WEST SUSSEX COUNTY COUNCIL CONSULTATION

TO:	Arun District Council FAO: Mrs A Gardner
FROM:	WSSC - Highways Authority
DATE:	24 January 2022
LOCATION:	7 Canada Road, Arundel, BN18 9HZ
SUBJECT:	AB/148/21/PL Demolition of 4no. existing bungalows and erection of 5 No. 2 bedroom dwellings with associated parking and landscape. This application is in CIL Zone 2 and is CIL liable as new dwellings.
DATE OF SITE VISIT:	n/a
RECOMMENDATION:	Advice
S106 CONTRIBUTION TOTAL:	n/a

Site Plan 1:200

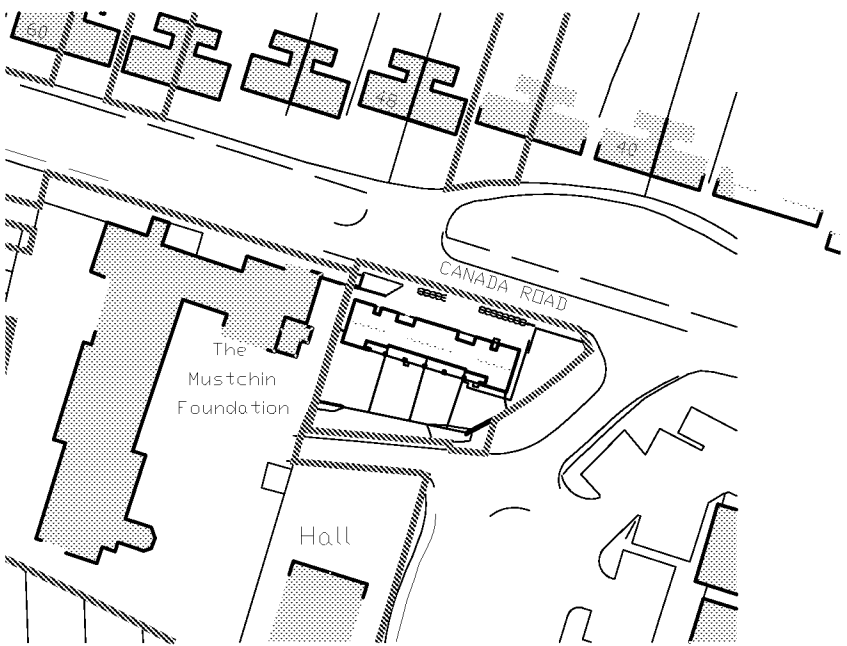
Access and parking will be provided in 2 locations. A layby arrangement will be created on Canada Road to provide 5 parallel spaces. An off-street space will be created via Hill Terrace to serve plot 1.

The layby arrangement will require works upon land consider public highway and without any 'Stopping Up' the spaces created could not be reserved for use specific use by residents of the proposed units. I note a slither at the southern extent of these spaces is not adopted highway. The footway realignment works to facilitate the creation of this layby are within private land. The highway works would therefore need to be implemented via a combined Section 38/278 Agreement. It is being considered by the Local Highways Authority that these layby spaces will ultimately be available for public use.

I would note that in principle the existing 4 dwellings were not provided with any off street car parking so the Local Highways Authority would not be minded to raise any overriding highway issues to the scheme citing parking even if no additional off street car parking was to be provided.

Plot 1 will be provided off street car parking. As such the parking at this plot should be EV enabled as per the Arun DC Supplementary Planning Document For Parking. The specific details of which can be secured via a suitably worded planning condition.
